RMS Ref: SYD16/00288 (A15081649)

Your Ref: SSD 7518

EXHIBITION OF EIS FOR UNSW KENSINGTON CAMPUS
ANZAC PARADE, KENSINGTON

Reference is made to your letter dated 22 September 2016 with regard to the abovementioned development proposal, which was referred to Roads and Maritime Services (Roads and Maritime) for comment.

Figure 4: Construction Vehicle Routes (Source: www.google.com.au)

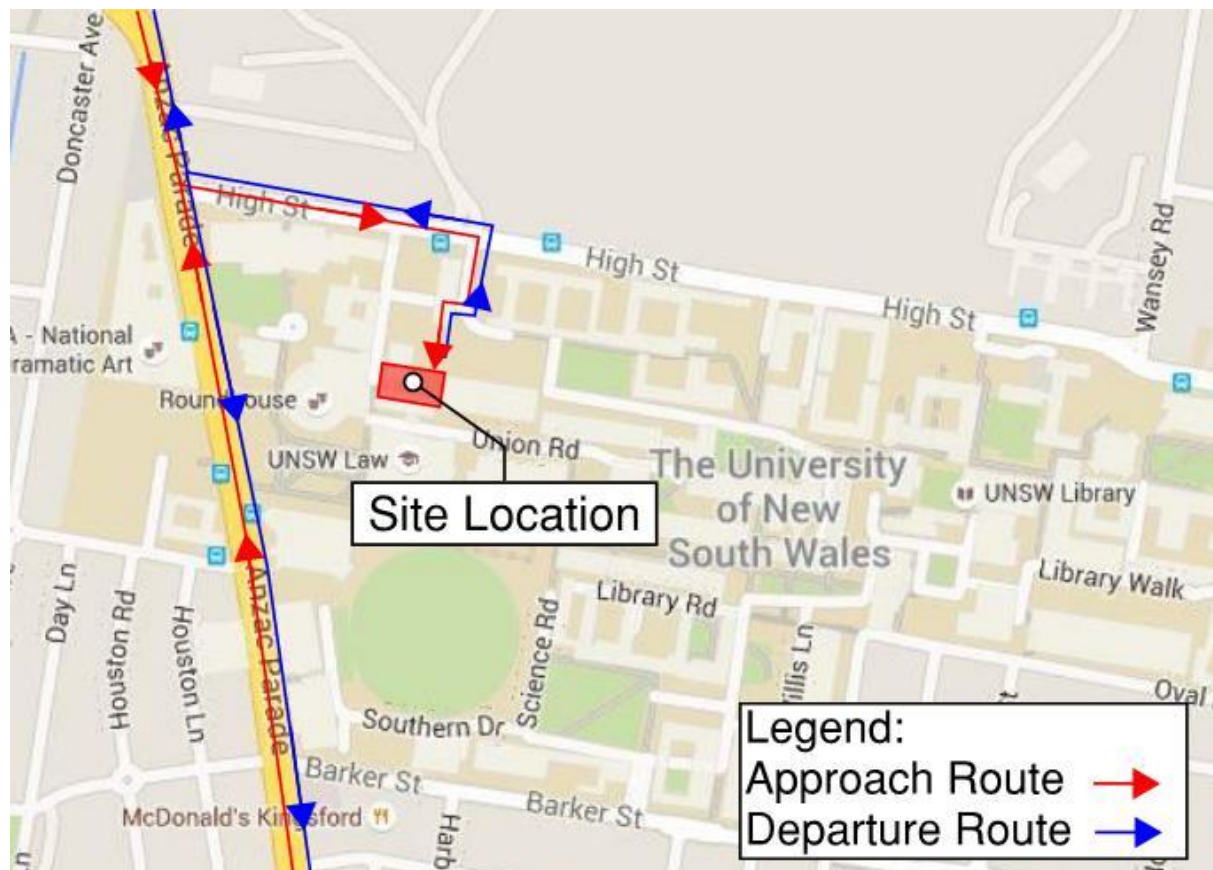
- a. The Preliminary Construction Traffic Management Plan shows a construction zone in High Street, Roads and Maritime understands this will be on the northern side of High Street between Anzac parade and Gate 2 entry. This section of High Street currently has 'No Stopping' full time to address efficiency and bus services in this area. A construction zone may not be supported in this area for the above reasons.

Sheet Subject
TURNING PATH - HRV

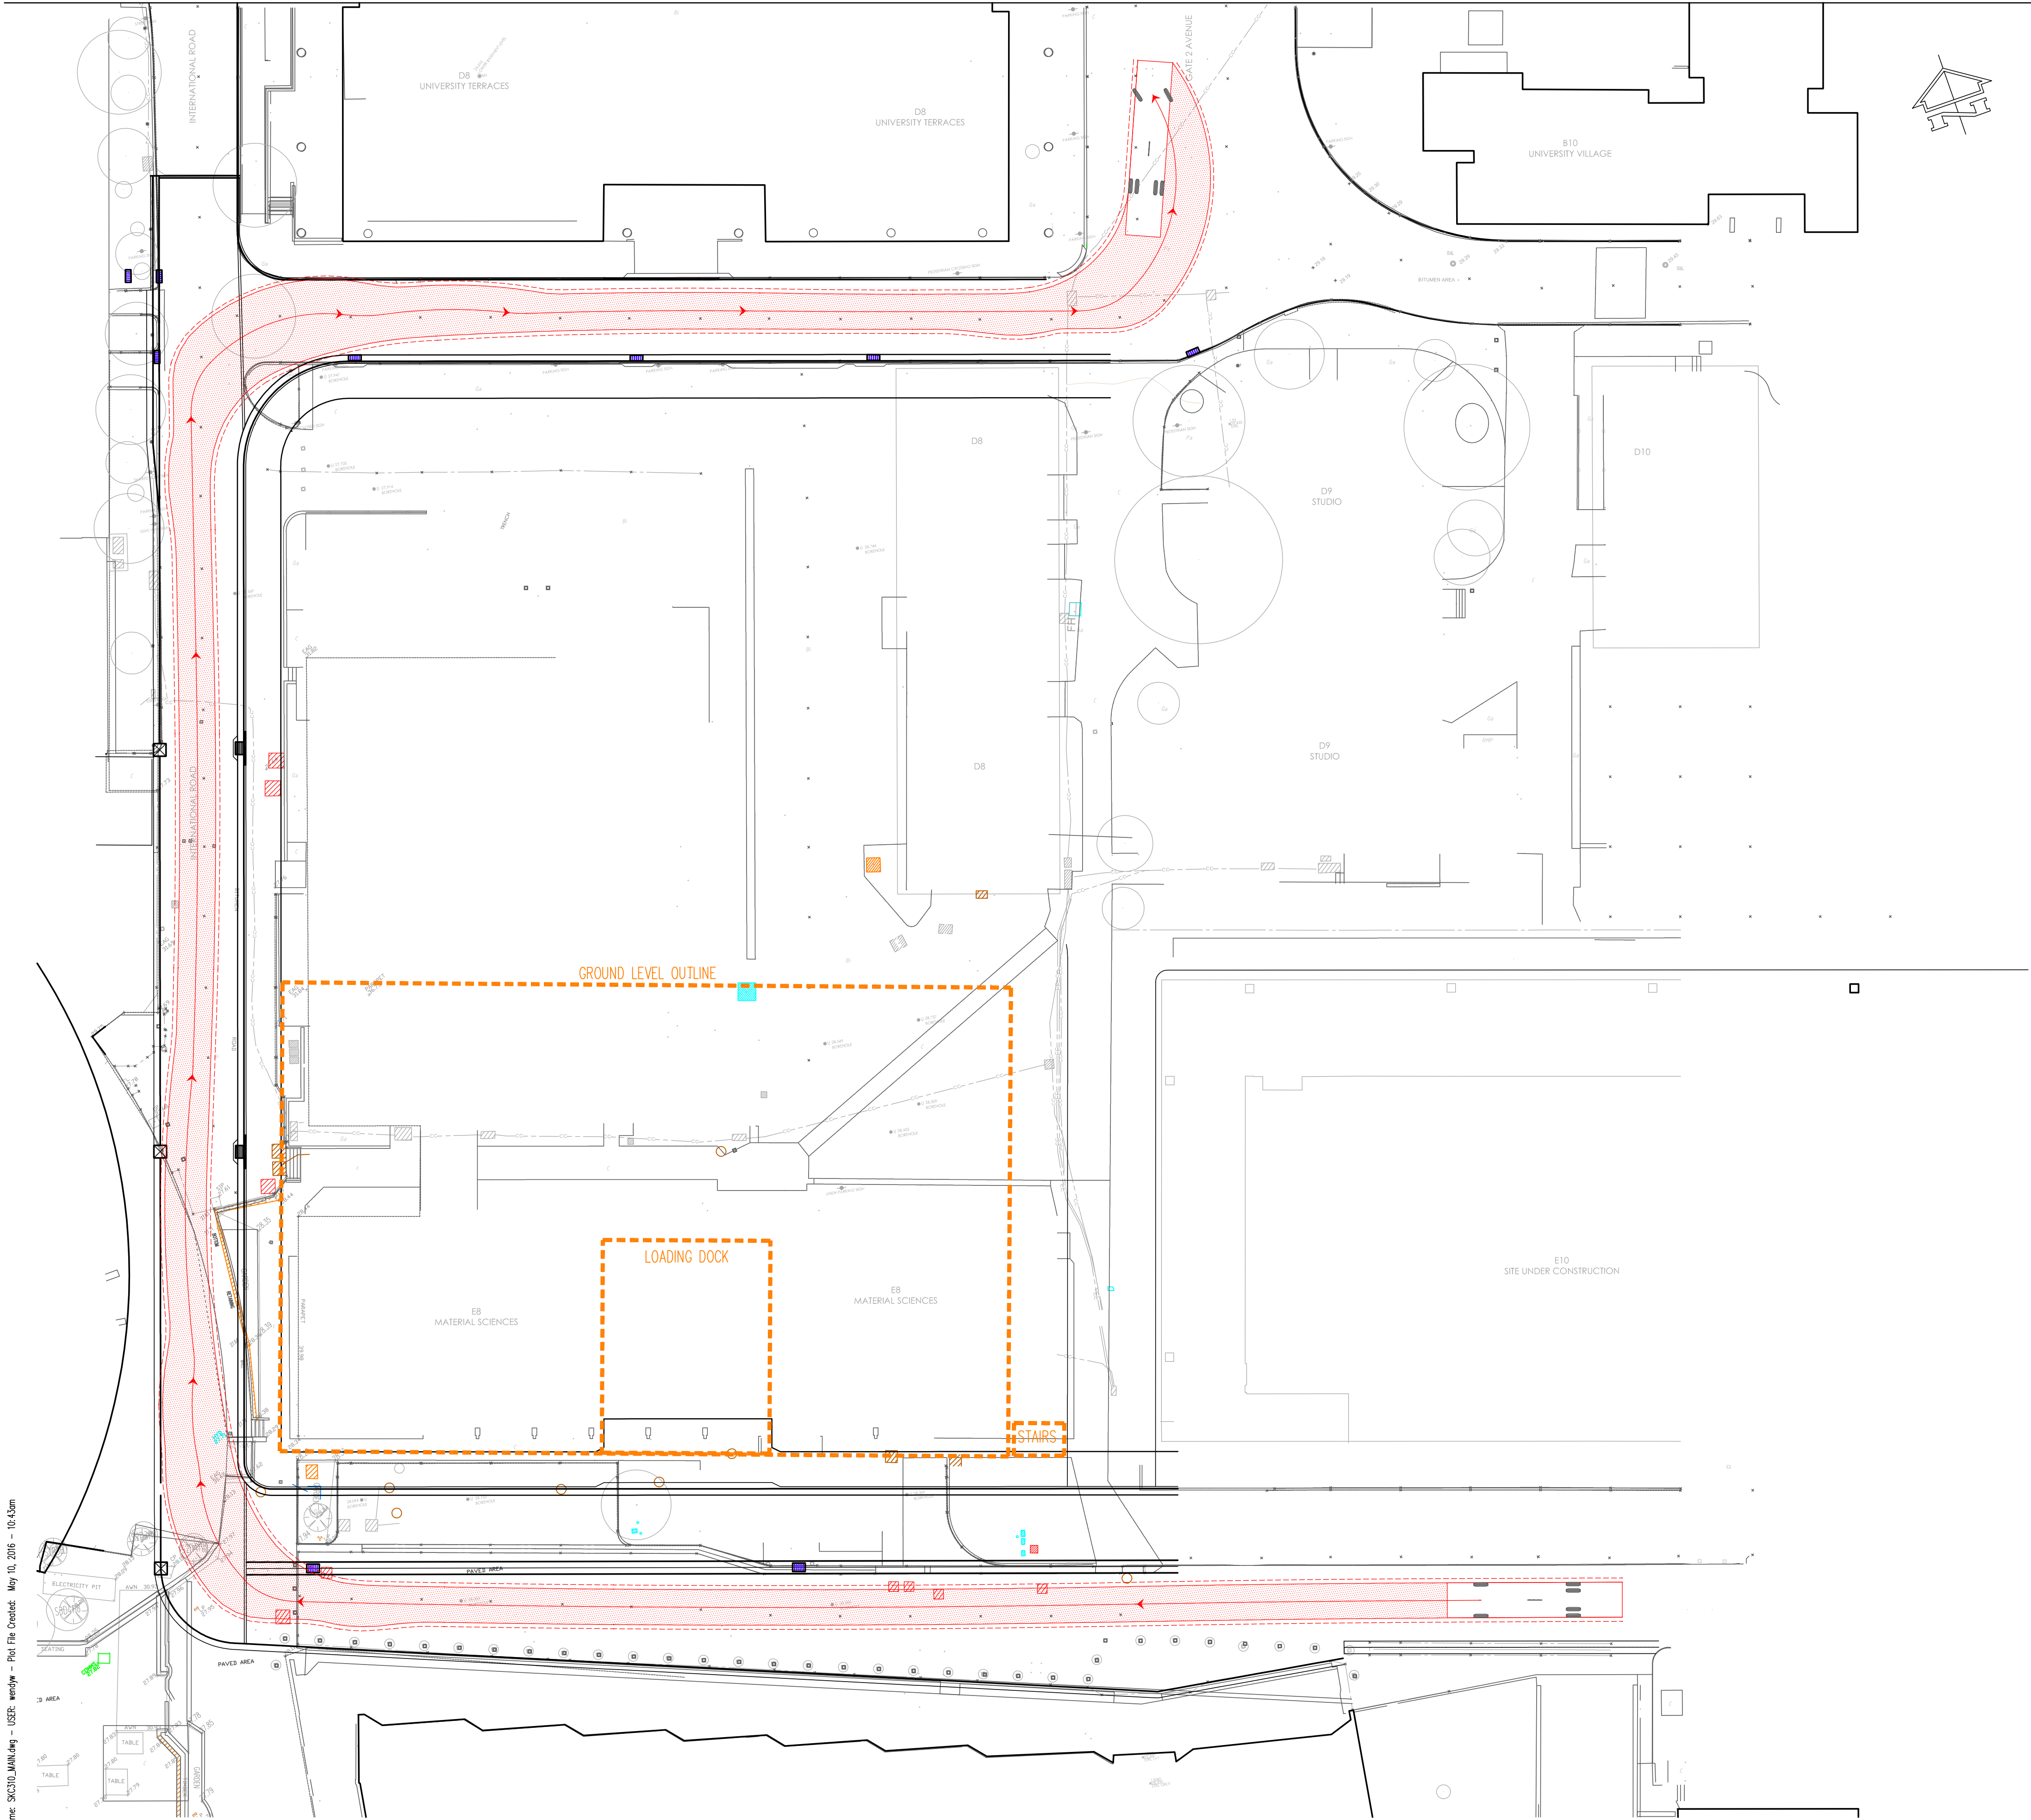
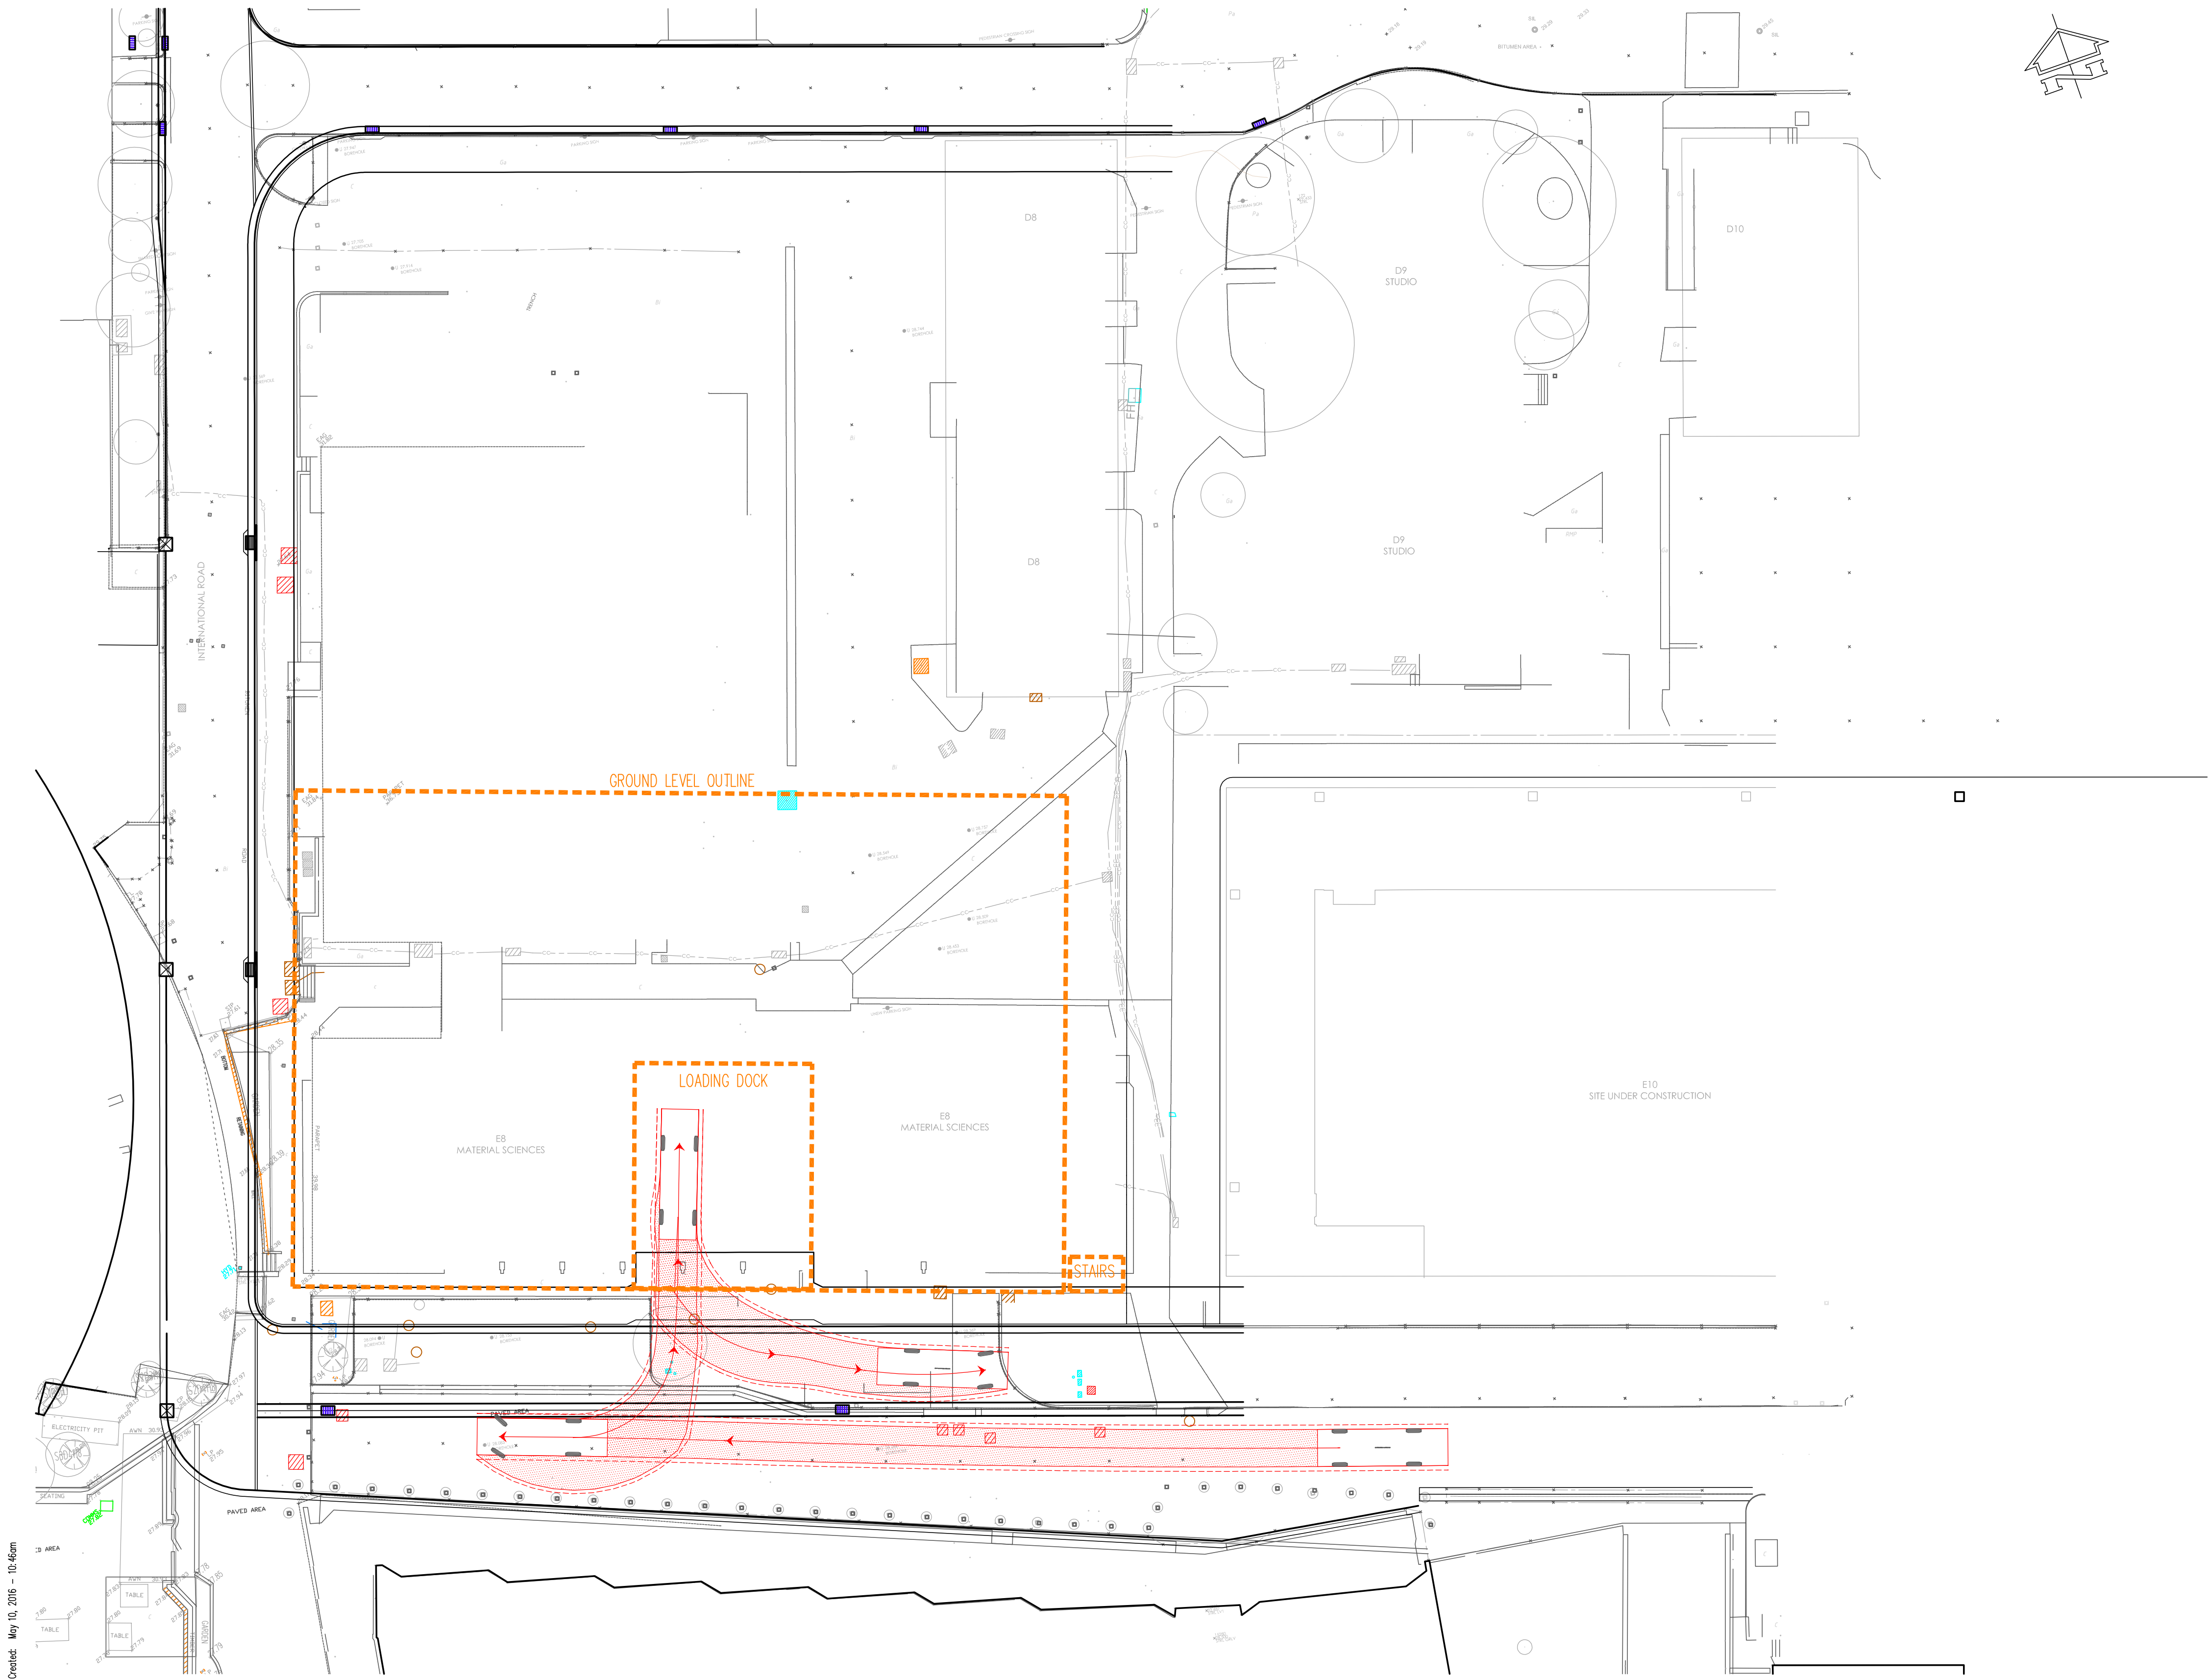
- a. In Appendix B turning paths are required to show construction vehicles can safely ingress and egress the campus from gate 2 onto High Street. The plans submitted only show internal site turn paths.
